EF13/4846, DOC18/83119-01

Cairncross Waste Management Facility Expansion (SSD 5792) – Notice of Exhibition

We have reviewed the DA and associated Environment Impact Statement ("EIS"). Comments, recommended conditions of consent, and requests for further information are provided in Attachment A to this letter.

ATTACHMENT A

Figure 1-10 Areas where maximum groundwater levels are above the landfill floor level

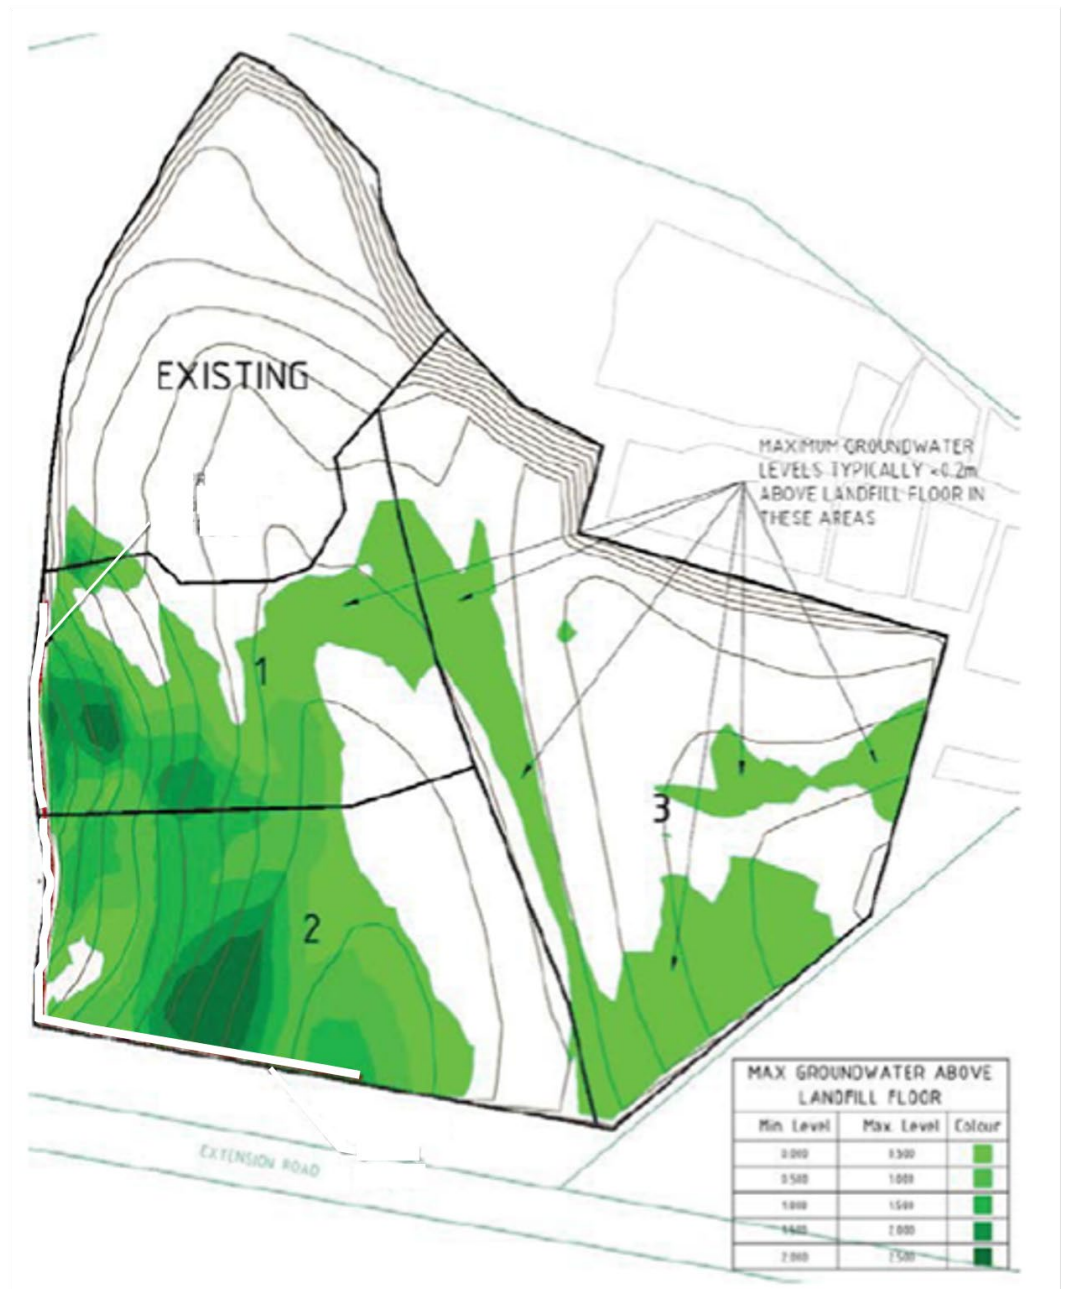
Figure 5-8 on Page 49 of the EIS shows areas where maximum groundwater levels are above the landfill floor level, and Figure 5-9 on Page 49 indicates the trench will only be installed where the maximum groundwater level is above the landfill floor level. There appear to be areas across Stage 3 where the maximum groundwater level is expected to be above the landfill floor level (albeit typically less than 0.2 metres), and yet it is not proposed to extend the trench towards Stage 3 (there appears to be a contradiction between Figure 5-8, which suggests there are areas across Stage 3 where maximum groundwater levels are above the landfill floor level, and the statement on Page 28 of the Hydrogeological Assessment' that: "*Within Stage 3 there is a very small area in which the maximum groundwater head will exceed 0.2 m above the average groundwater head (i.e. a maximum of 1.8 m below the landfill floor) ...*"

Additionally, Figure 5-9 indicates the trench will not be installed in areas where the maximum groundwater level is at, or above, the depth of excavation (0.5 metres) and at or below the landfill floor level (two metres). The EPA is concerned that in areas where the maximum groundwater level is between 0.5 metres and two metres above average groundwater level, upward pressure may be exerted by rising ground waters on the underside of the landfill barrier system, which may compromise the long-term integrity of the system. The EPA will consequently be requiring that the proposed gravel/rubble trench be extended into areas where the maximum groundwater level is expected to be above the level of excavation.

According to the Hydrogeological Assessment (Page 28): "*It is assumed that the drainage trench will be constructed during the development of Stages 1 and 2, and within 100 days of the start of each of the stage excavations*". If the trench is only to be constructed along the western boundary of Stage 1, there may be groundwater inflows from the south of Stage 1, until the trench is constructed along the southern boundary of Stage 2.

Recommended condition: Prior to construction of the gravel/ rubble trench, detailed technical specifications including full construction plans for the trench must be submitted for approval by the EPA.
